Submission ID: S747DE431

Objection to East Pye Solar Project – Alyson Read

I live in Tivetshall which has Land Parcel 2, 400kv Project Substation, CRC and all associated infrastructure located within the parish.

Figure 11.2: Likely and Suitable Routes to the Scheme

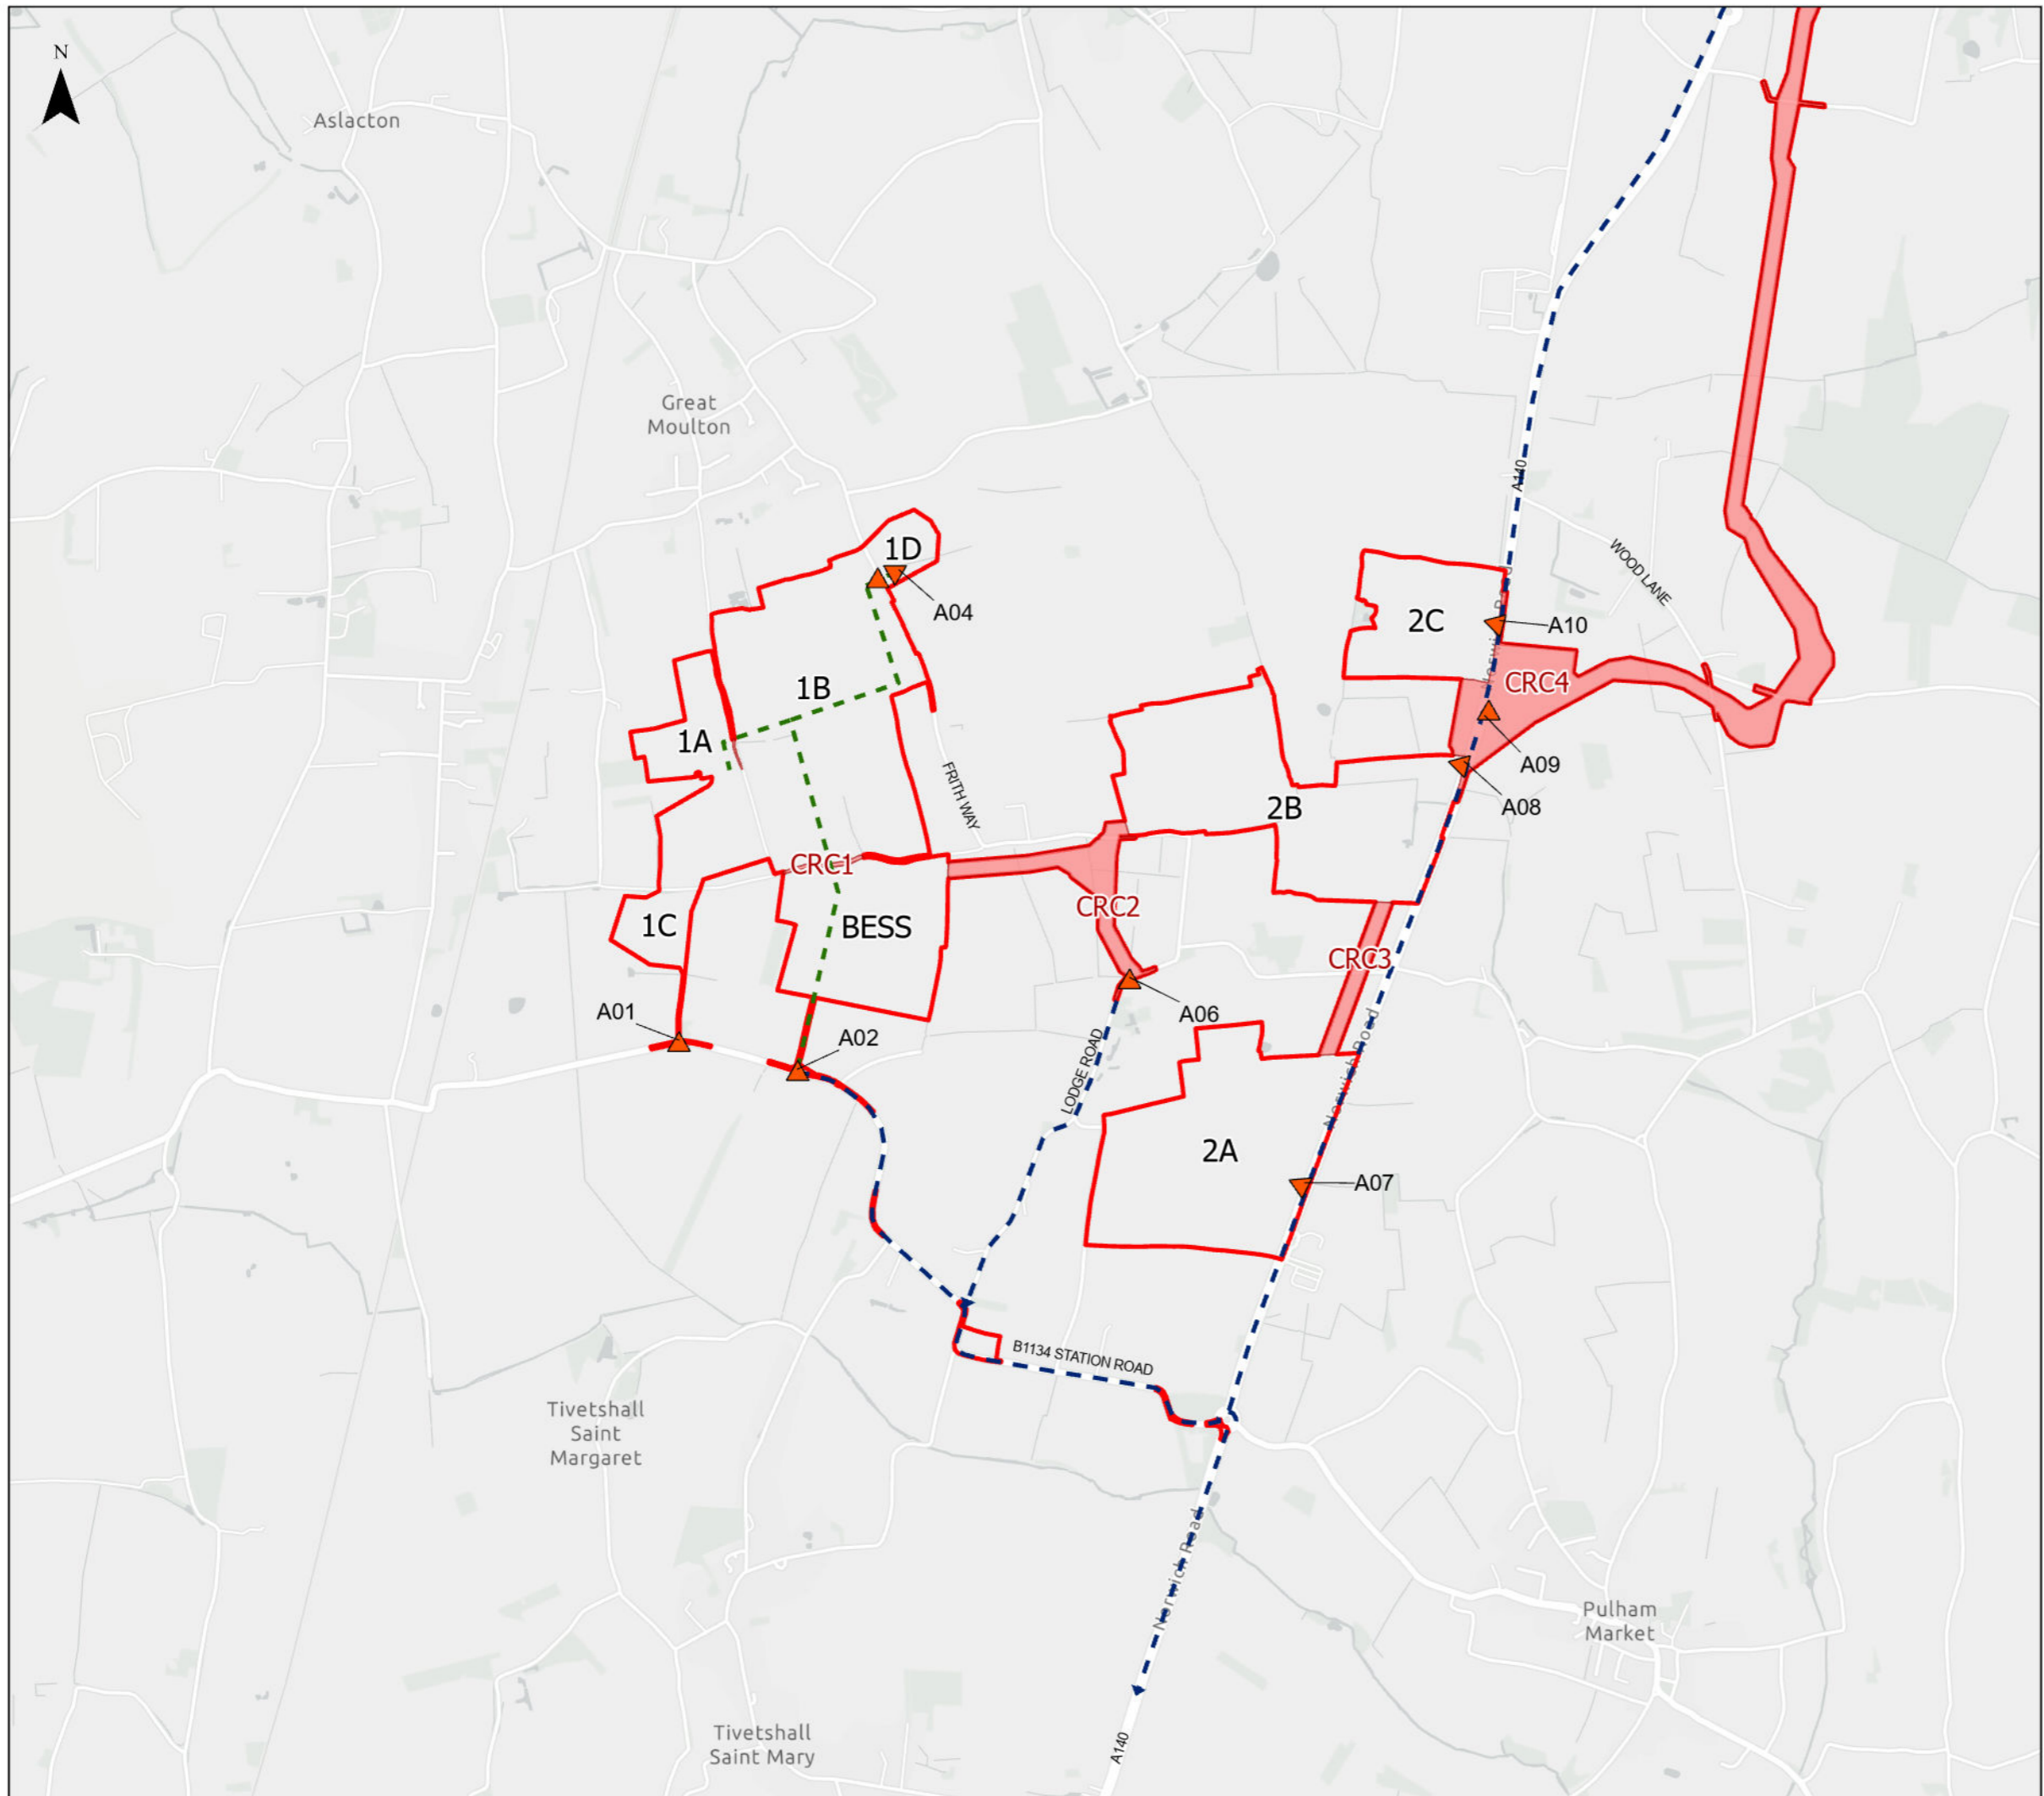
- 1. Transport and Access - Lodge Road Tivetshall St Margaret.** The Applicant refers to Lodge Road as a 'likely and suitable route'. The Applicant has conducted traffic surveys, including Lodge Road.

Inconsistency: The Applicant records an 0% increase on Link 16. This is nonsensical. Lodge Road is identified for access during all 3 phases of the East Pye Solar Project, then includes a chart indicating there will be no increase in vehicle movements.

I request the ExA should seek an explanation of how A05 and A06 are both intended to be used during construction, including access associated with CRC2, on what routing assumption does Table 11.16 show zero scheme traffic increase on Link 16 Lodge Road?

- Lodge Road is a single track rural lane.
- In places less than 2.7m wide.
- No information on the changes necessary to accommodate 2 way construction and decommissioning traffic (presumably large vehicles over 3.5t).
- It forms part of the Rebellion Way cycle route.
- FP10, Prangle Lane Bridlepath BR9, FP8, FP4, FP5, Walk Farm Bridlepath BR7, Restricted Byway (no motorised traffic) RB6
- Lodge Road Tivetshall St Margaret and Frith Way Great Moulton are one continuous route.

I request the ExA to remove Lodge Road as a likely and suitable route and accept the Norfolk CC Highway proposal that access is restricted to A and B roads and all other routes should be within the site boundaries which are all interconnected.
